City of Portland, Maine - Building or Use Permit Application

Permit No: 02-1012	Issue Date: OCT 18 2002	CBL: 057 K001001
-----------------------	----------------------------	---------------------

Location of Construction: 208 Danforth St	Owner Name: Dana Thomas H	Owner Address: 715 Chandler's Wharf	Phone: 207-772-9578
Business Name:	Contractor Name:	Contractor Address:	Phone:
Lessee/Buyer's Name	Phone:	Permit Type: Alterations - Dwellings	Zone: R-6

Re: 208 Danforth Street – exterior alterations

EXHIBIT 5

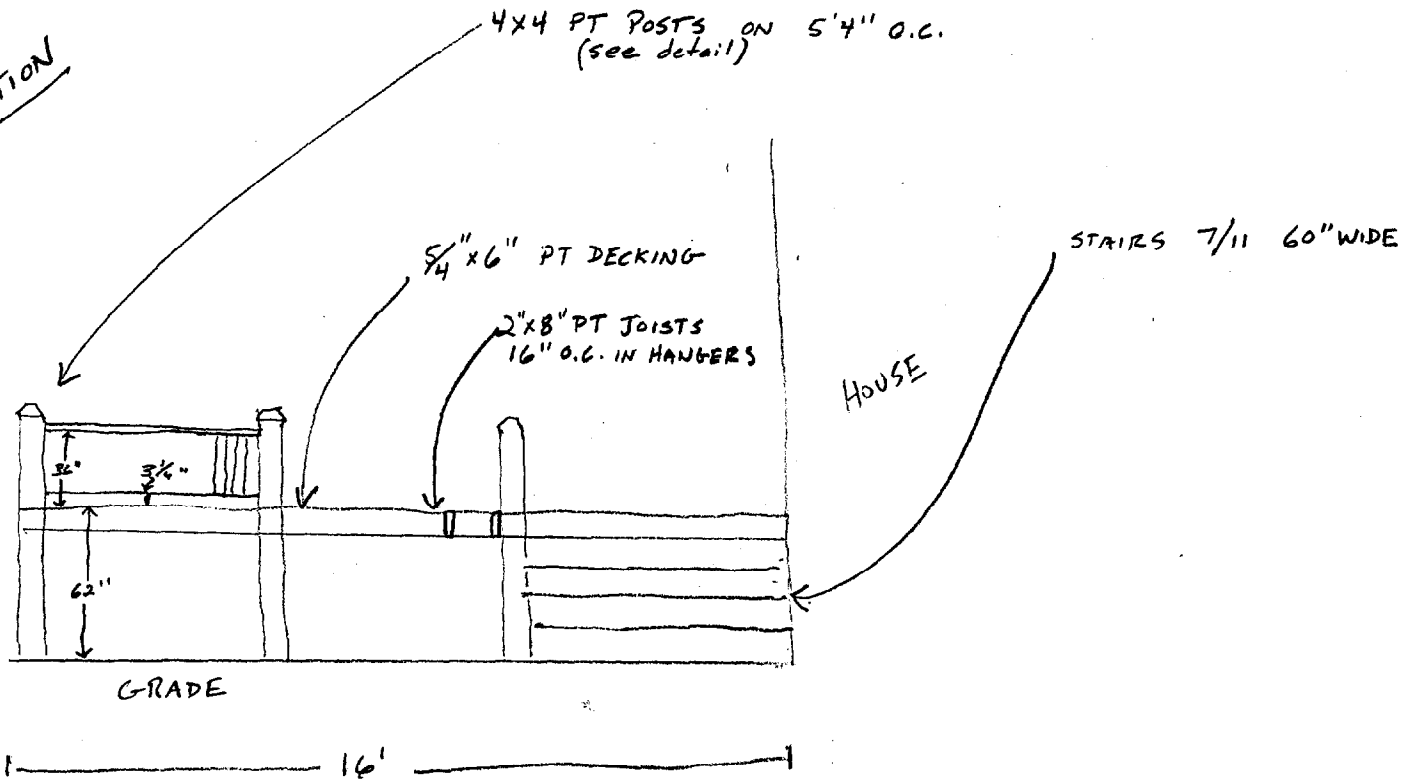
Band Joist must be DOUBLE 2"x 8" minimum. Joist hangers on all joists. Ledger/ Band affixed to house must be Flashed, Lagged in a structurally appropriate manner

All guards must be 36" with openings less than 4 inches, handrails must be graspable.

Comments: 09/19/02 no plot plan attached - what fire escape is being removed - where - etc. Left a voice mail with Thomas Dana to supply such info
9/24/02 talked to Todd Dana who explained location and use and proposed job
